MEMORANDUM

To: FILE
From: Nell Donaldson
Subject: Application ID: 2014-220
Date: 4/8/2015

Comments Submitted by: Jeff Tarling/City Arborist on 3/23/2015

I have reviewed the recent revised landscape plan and find the plan acceptable as shown.

Sheet Title:
LANDSCAPE AND LIGHTING PLAN

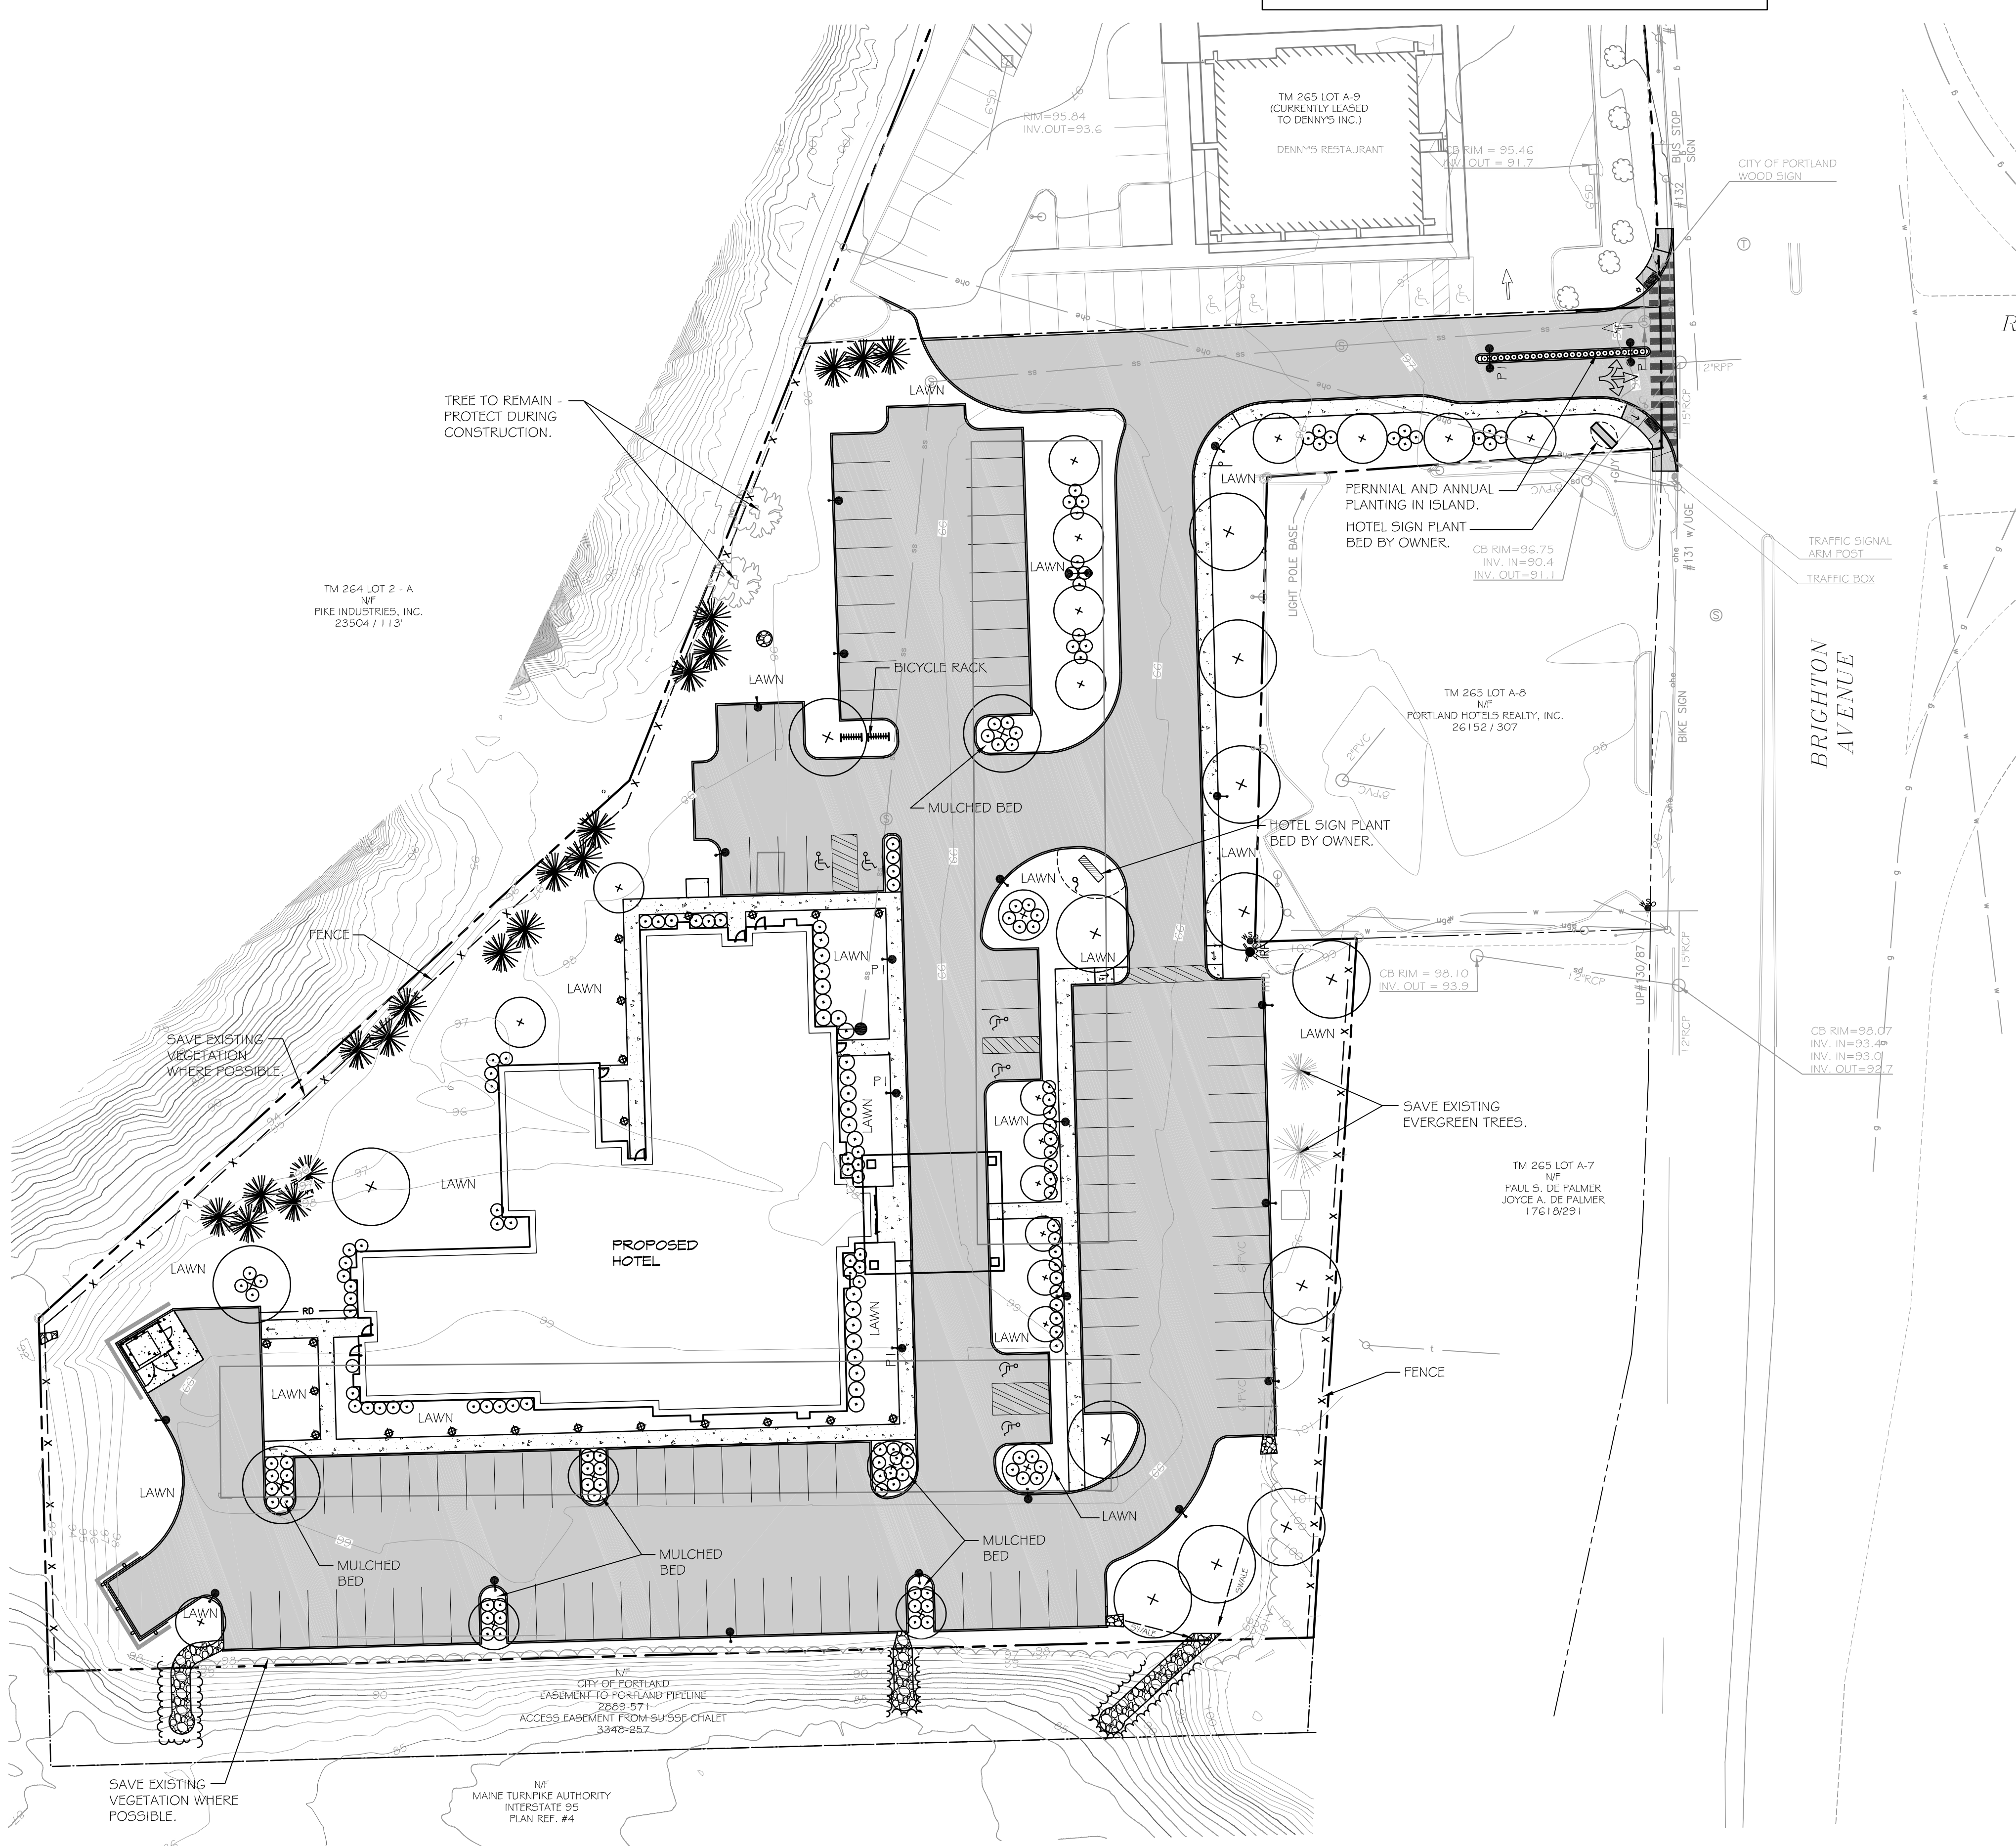
They seem to meet the numbers although they do not have the typical 'street', only the parking lot and fringe areas. The new plan shows what looks like are enough 'street trees' to meet the criteria:

Great. Can you look at the street tree question when you do? They're technically not meeting the requirement by putting a tree in the ROW, but there are some small trees near the property line. Do they qualify or do we need a contribution?

The revision includes the recommended additional trees along the Maine Turnpike and improved landscape key with plant & tree details.
